**WELWYN HATFIELD BOROUGH COUNCIL
EXECUTIVE DIRECTOR - PLANNING, PUBLIC PROTECTION AND GOVERNANCE**

Application No: 6/2022/1248/LAWP
Location: Manor Cottage Vineyards Road Northaw Potters Bar EN6 4PQ
Proposal: Certificate of Lawfulness for the erection of a single storey side extension
Officer: Ms Kirsty Shirley

Recommendation: Refused

4 Proposed Roof Plan
1:100

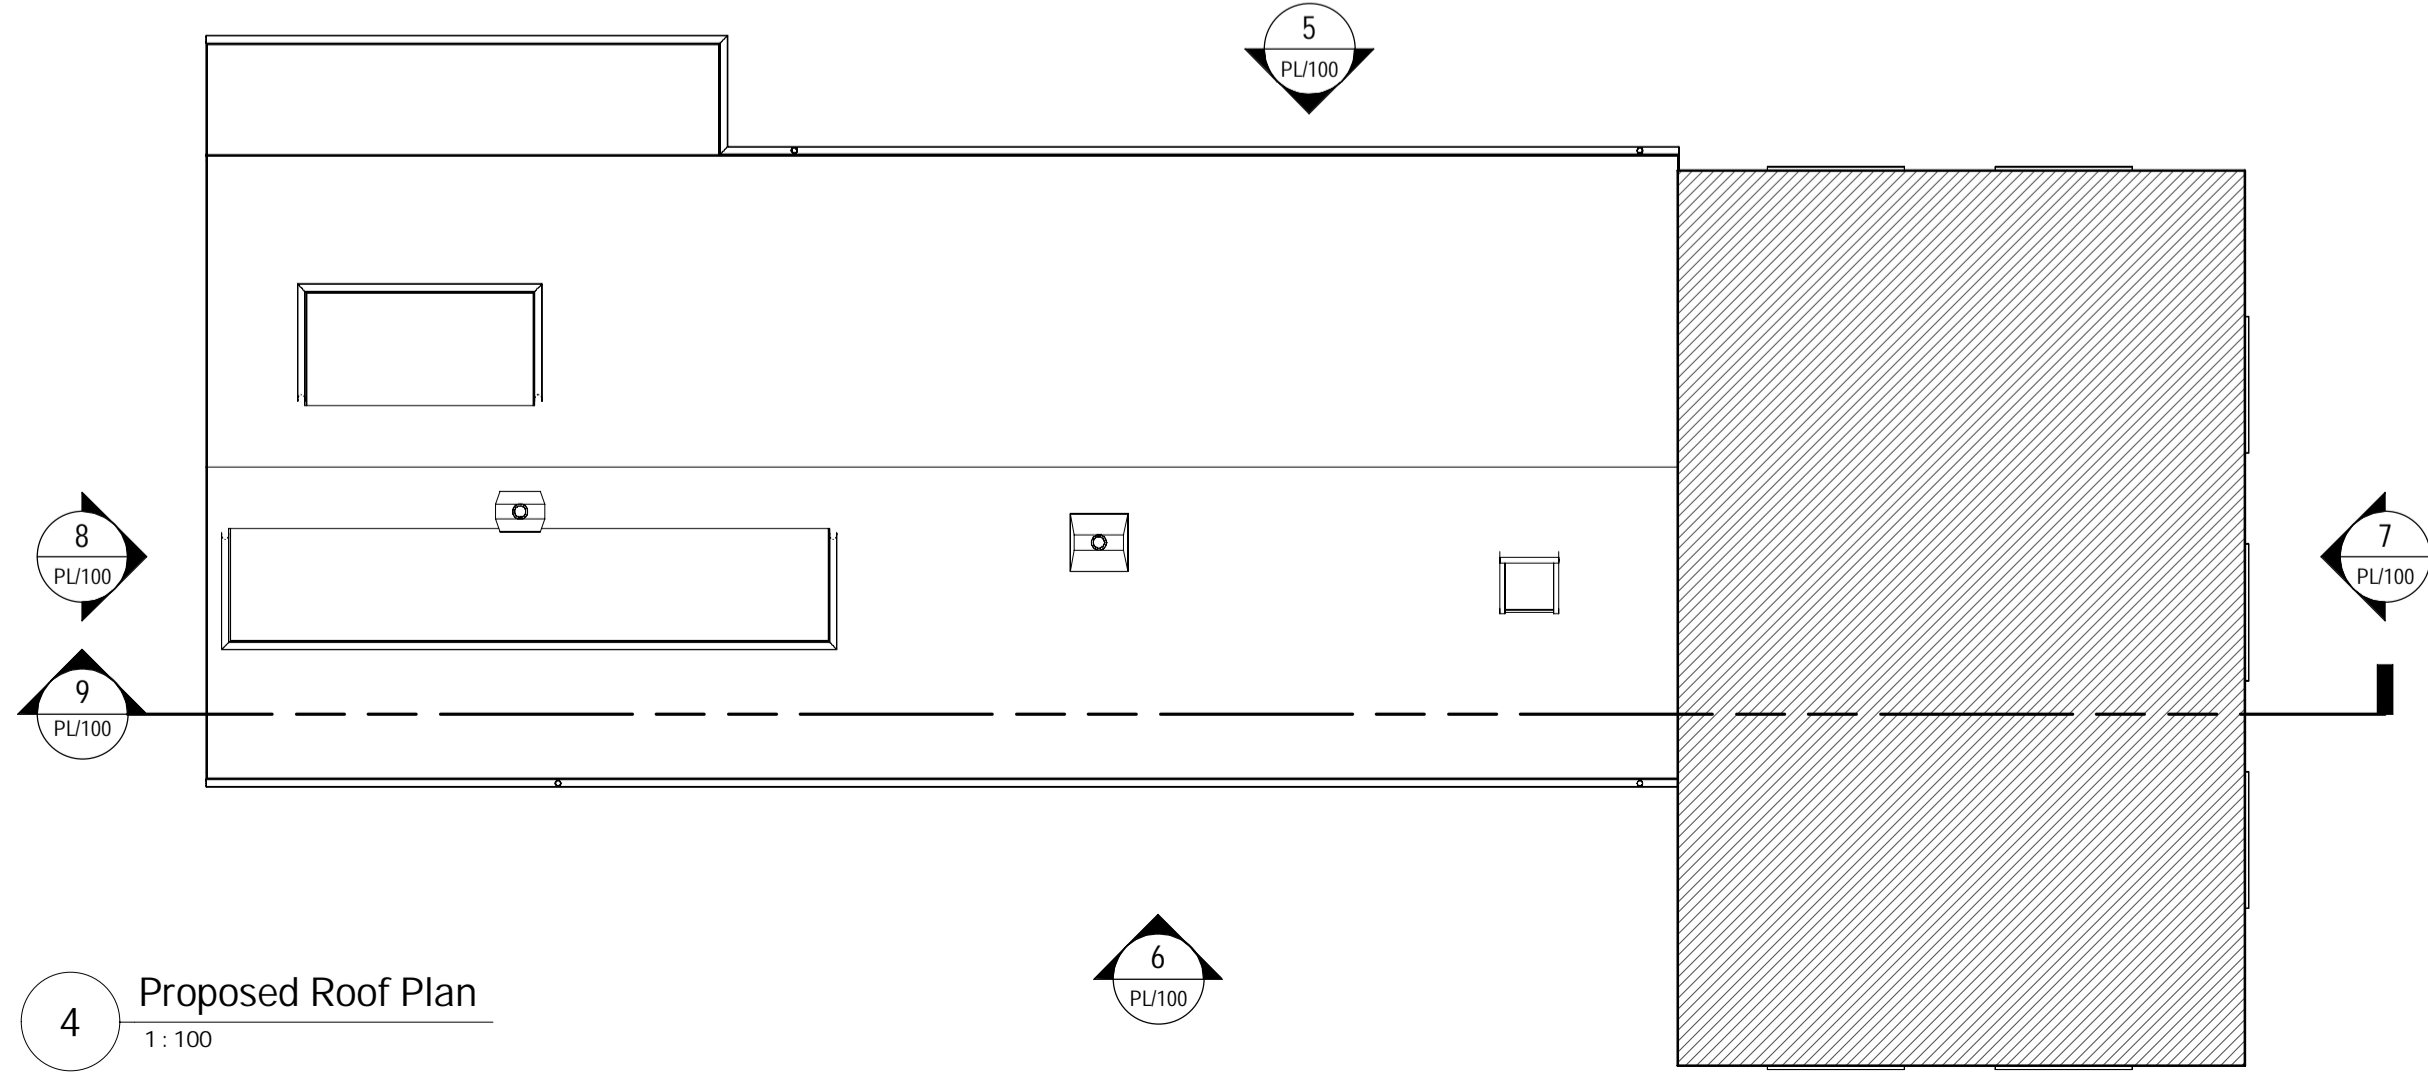
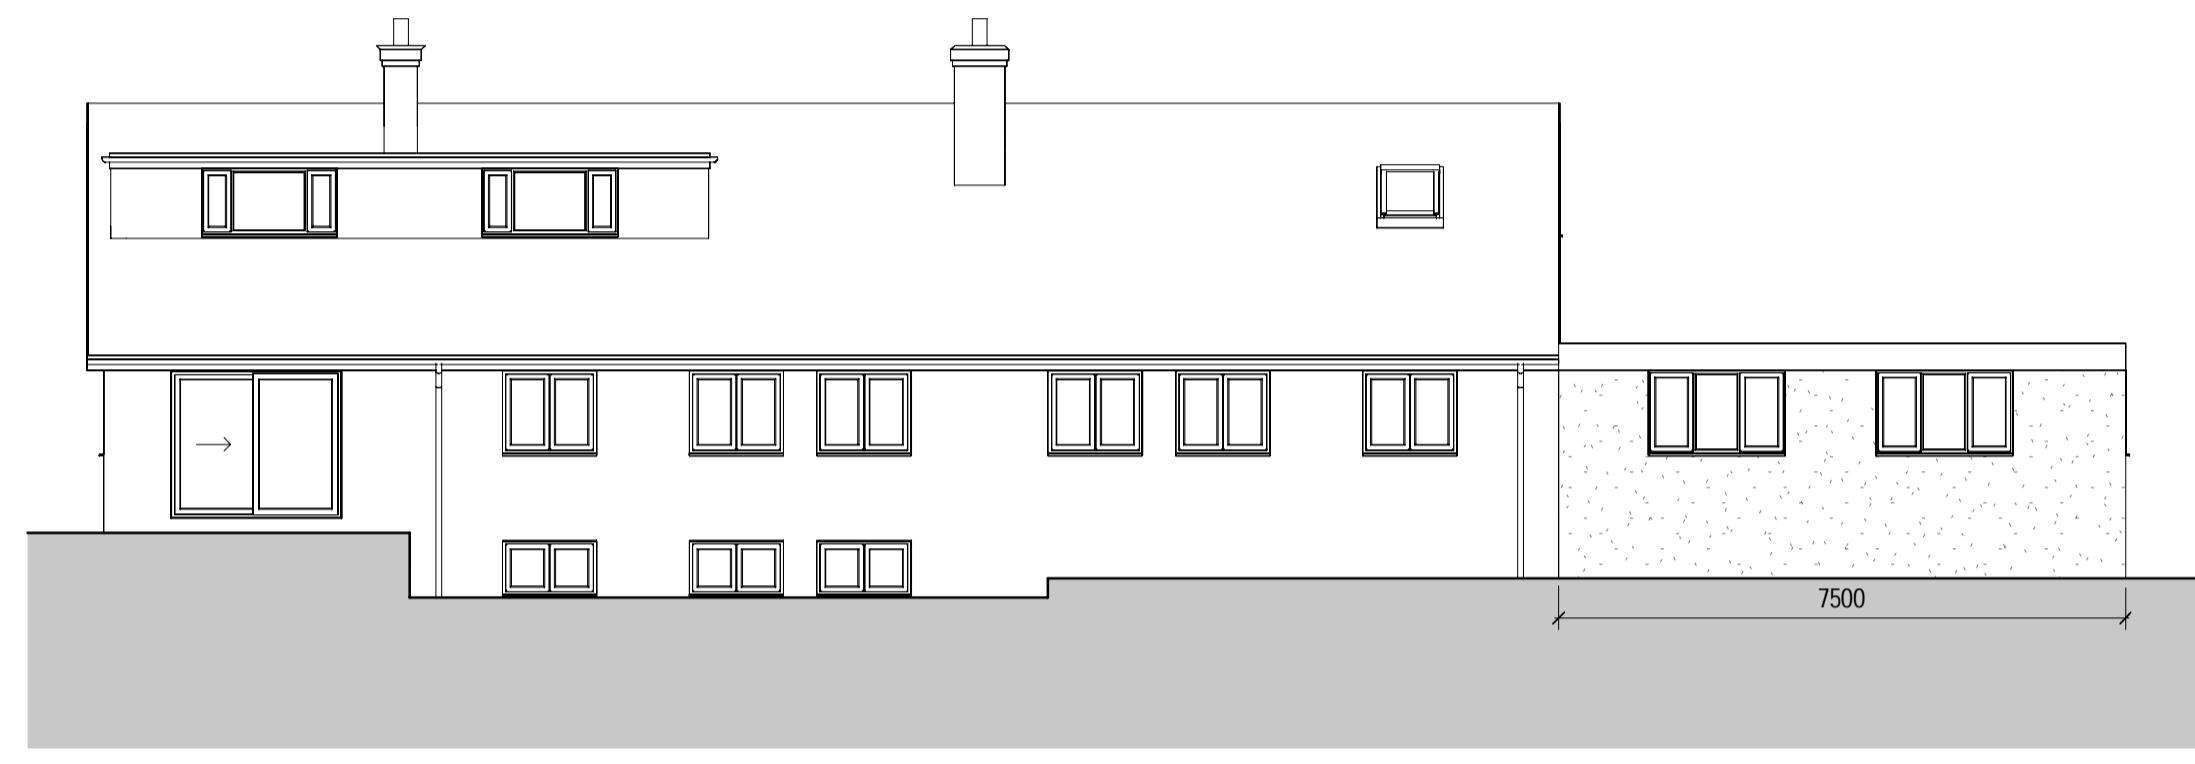
(e) would the enlarged part of the dwellinghouse extend beyond a wall which:- (i) forms the principal elevation of the original dwellinghouse; or (ii) fronts a highway and forms a side elevation of the original dwellinghouse	Y	N

(c) would, where the enlarged part of the dwellinghouse has more than one storey, the roof pitch of the enlarged part, so far as practicable, be the same as the roof pitch of the original dwellinghouse	N/A	N
Discussion		
<p>The Permitted development rights for householders Technical Guidance advises the extent to which an elevation of a house fronts a highway will depend on factors such as:</p> <p>(i) the angle between the elevation of the house and the highway. If that angle is more than 45 degrees, then the elevation will not normally be considered as fronting a highway;</p> <p>(ii) the distance between the house and the highway - in cases where that distance is substantial, it is unlikely that a building can be said to front the highway. The same may be true where there is a significant intervening area of land in different ownership or use between the boundary of the curtilage of the house concerned and the highway.</p> <p>The proposed flank elevation of the side extension would directly face Vineyards Road. Furthermore, the flank elevation of the extension would be approximately 20m from Vineyards Road, an insubstantial distance from Vineyards Road with no significant intervening area of land in different ownership or use between the boundary of the curtilage of the application dwelling and Vineyards Road.</p> <p>The proposed development would therefore extend beyond a wall which fronts a highway and forms a side elevation of the original dwellinghouse, failing to meet the criteria of Schedule 2, Part 1, Class A (e) (ii) of the Town and Country Planning (General Permitted Development) (England) Order 2015 as amended.</p>

Conclusion		
<p>The proposed side extension would not meet the criteria of Schedule 2, Part 1, Class A (e) (ii) of the Town and Country Planning (General Permitted Development) (England) Order 2015 as amended.</p>
